16 February 2026

SSD-10455 Middlebrook Solar Farm, Middlebrook Road, Middlebrook - Review of Modification 1

TfNSW has reviewed the *Modification Report Middlebrook Solar Farm dated November 2025, Project Number: 230488 prepared by NGH Pty Ltd*, and *Middlebrook Solar Farm - SSD-10455 Traffic and Transport Assessment, Reference No.101 dated 28 October 2025 prepared by Amber Organisation*. and understands the proposed amendments in relation to traffic and transport sought to be as follows:

Figure 1: Proposed Farm Access Location

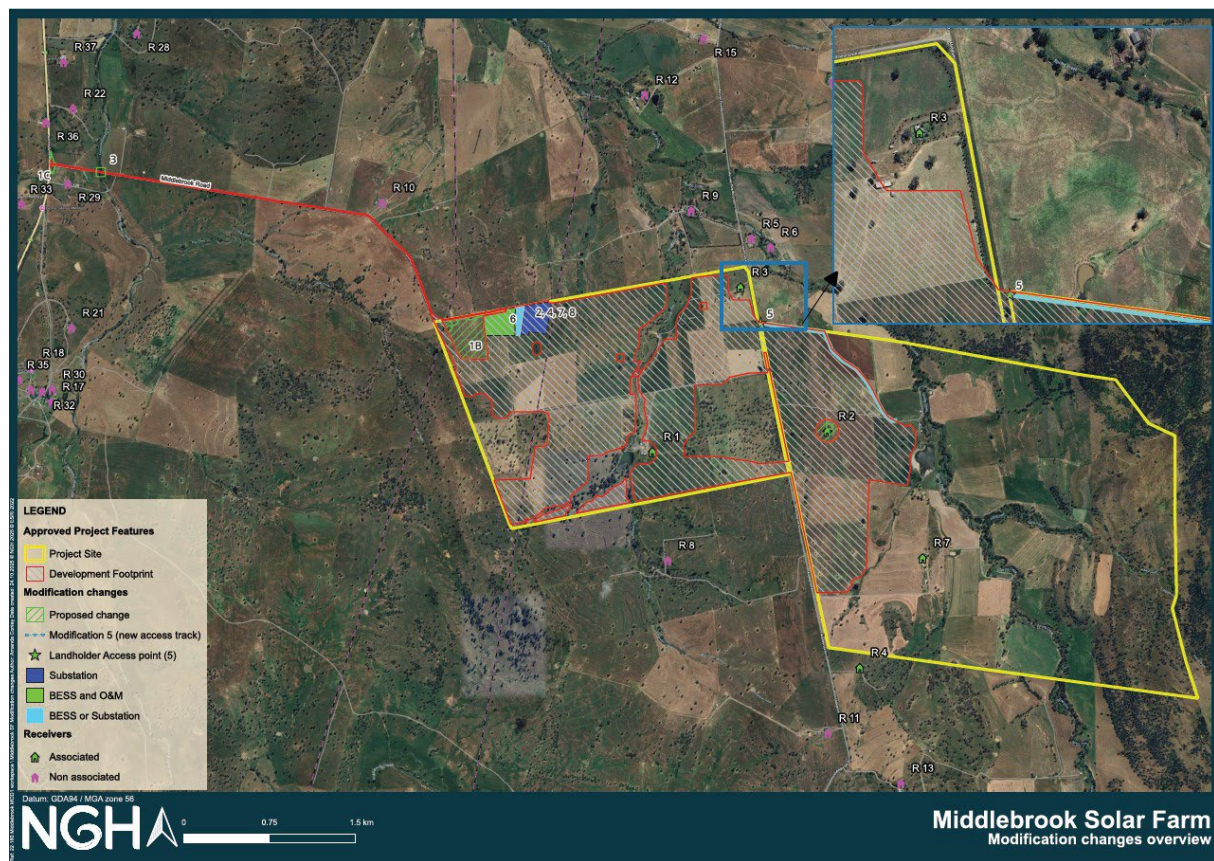
3. The proposed new farm access from Middlebrook Road is to be included within Appendix 5 – Road Upgrades and Site Access.
4. A new condition is to be included under Site Access identifying that the new farm access is not to be used by Project traffic.
